From: 
Sent: Douglas Briggs Partnership 
To: 22 April 2014 16:51
Cc: Simon Davis
Subject: Andrew Henry
REF EG/23/14 Proposed Windbreak @ Springfield Nursery, Barnham

From: Simon Davis [<mailto:Simon.Davis@arun.gov.uk>]
Sent: 17 April 2014 16:58
To: 'architecture@douglasbriggspartnership.co.uk'
Subject: FAO Mr Paul Hughes REF EG/23/14 Proposed Windbreak @ Springfield Nursery, Barnham

Windbreak Block Plan 1:500

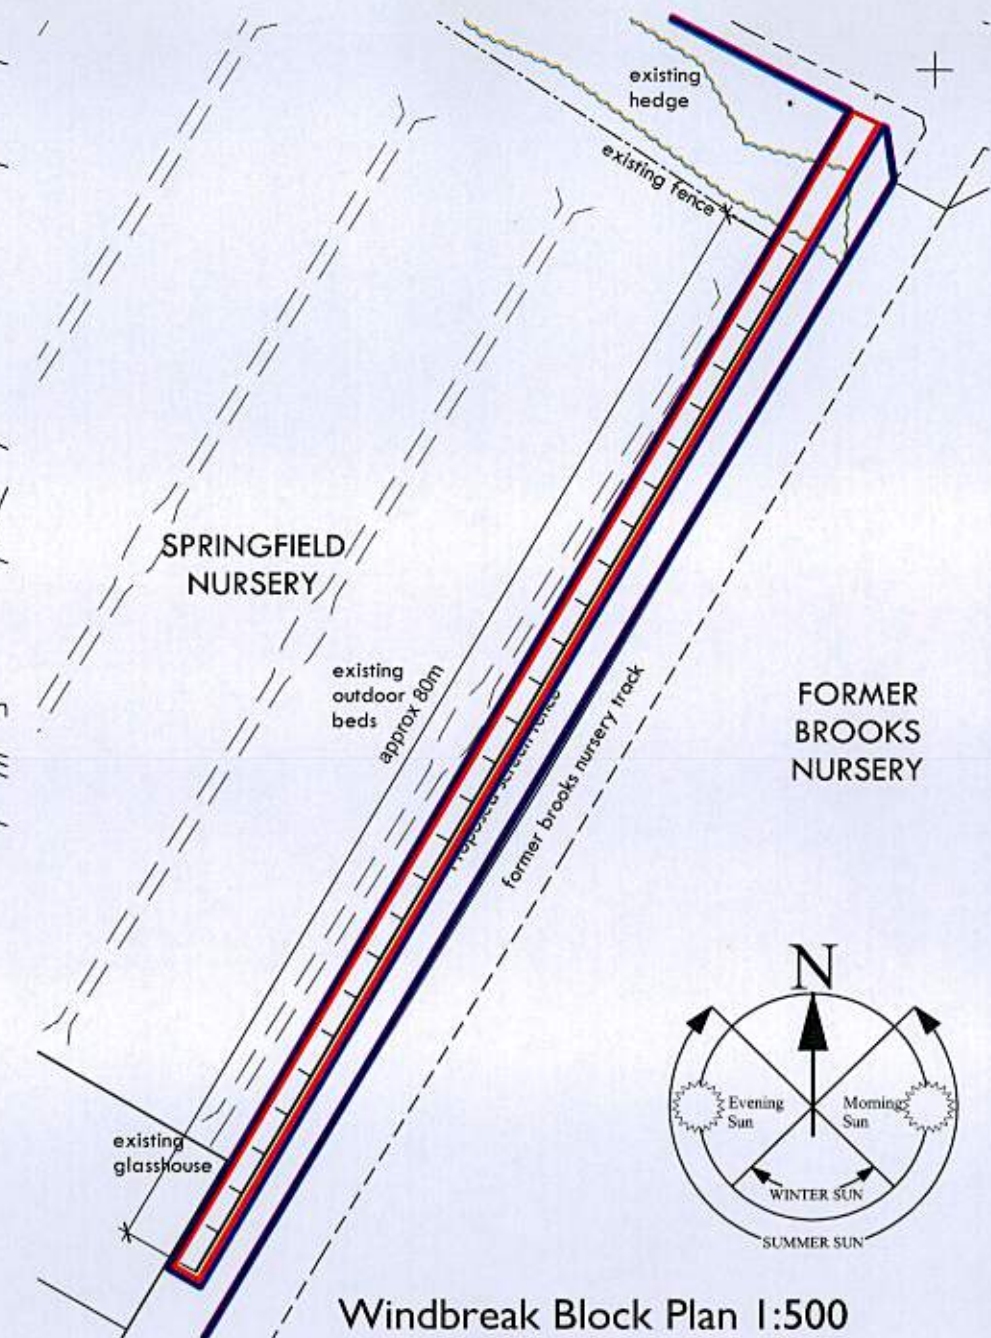
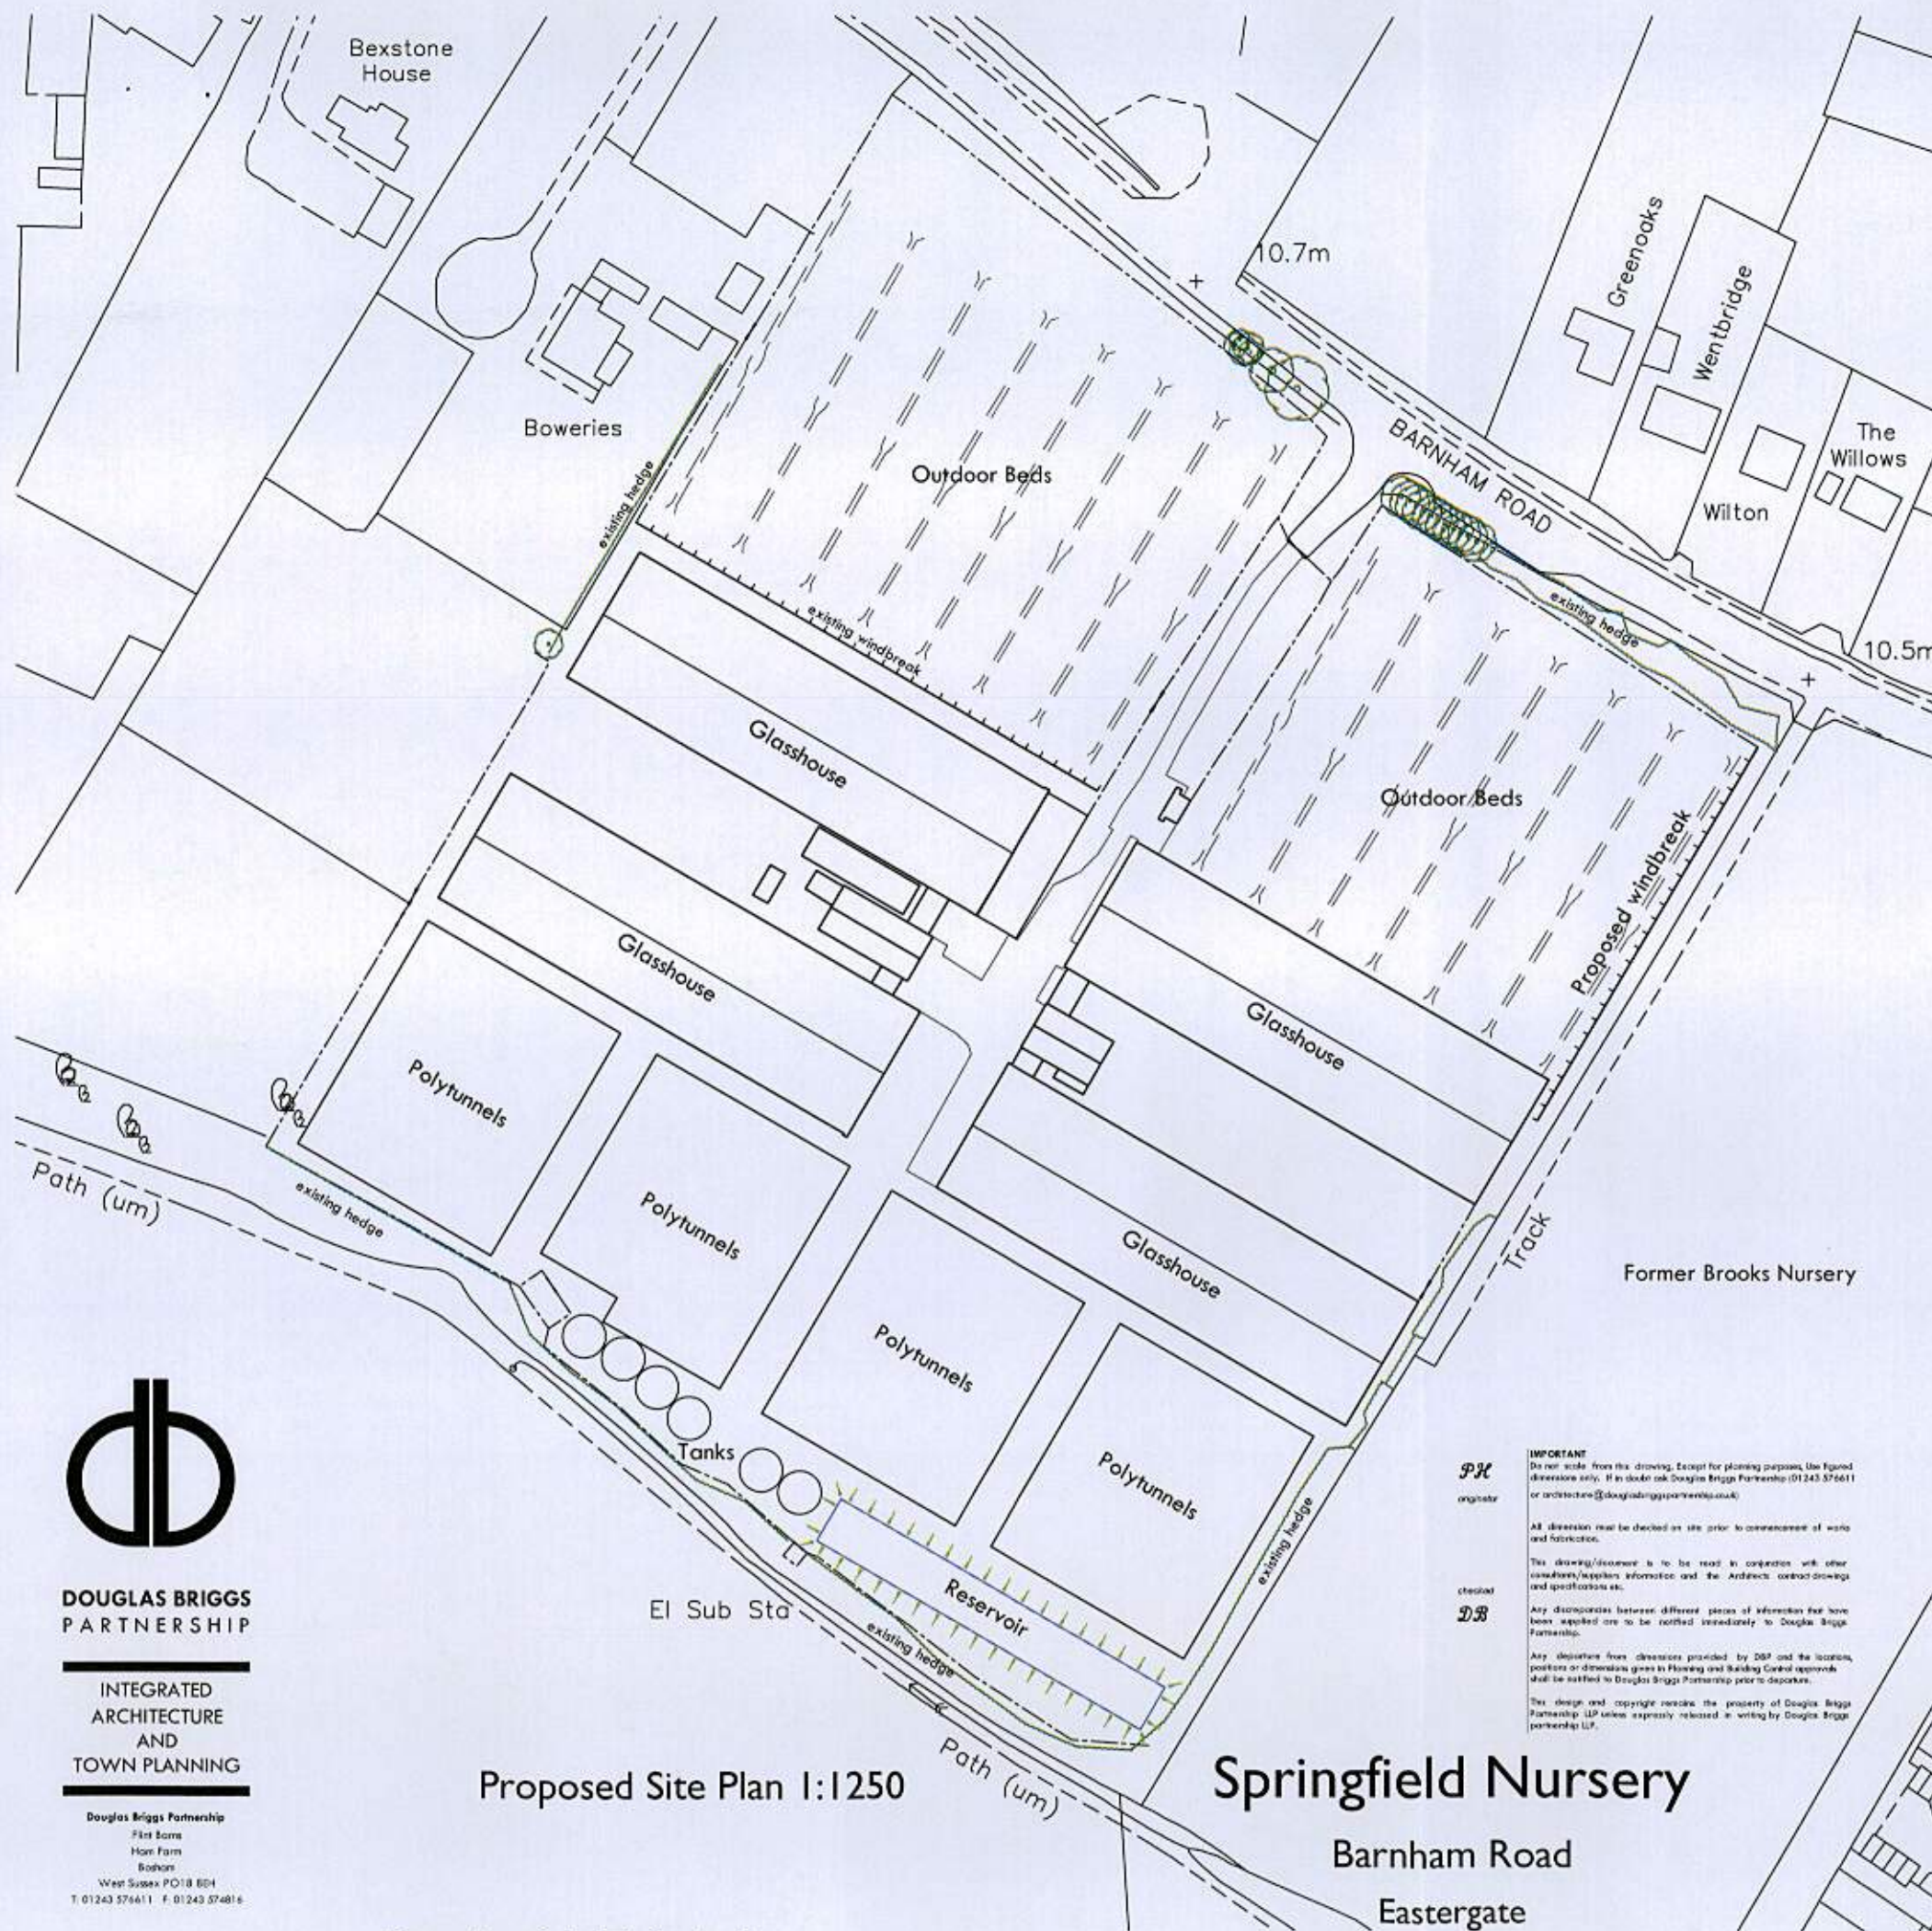
I am the case officer for this application. I have visited the site this afternoon but I wanted to check the siting of the windbreak with you as it wasn't totally clear. Is the windbreak being sited between the existing bund and the screen fence to Brooks or will it be the other (western) side of the bund? I assume it will not be atop the bund.

I have spoken to the applicant who has informed me that the mound of earth is temporary, being the result of levelling in the growing area and will be spread on the field in due course.

The proposed windbreak will be constructed at the field level as close to the fence boundary as possible, while allowing access for maintenance.
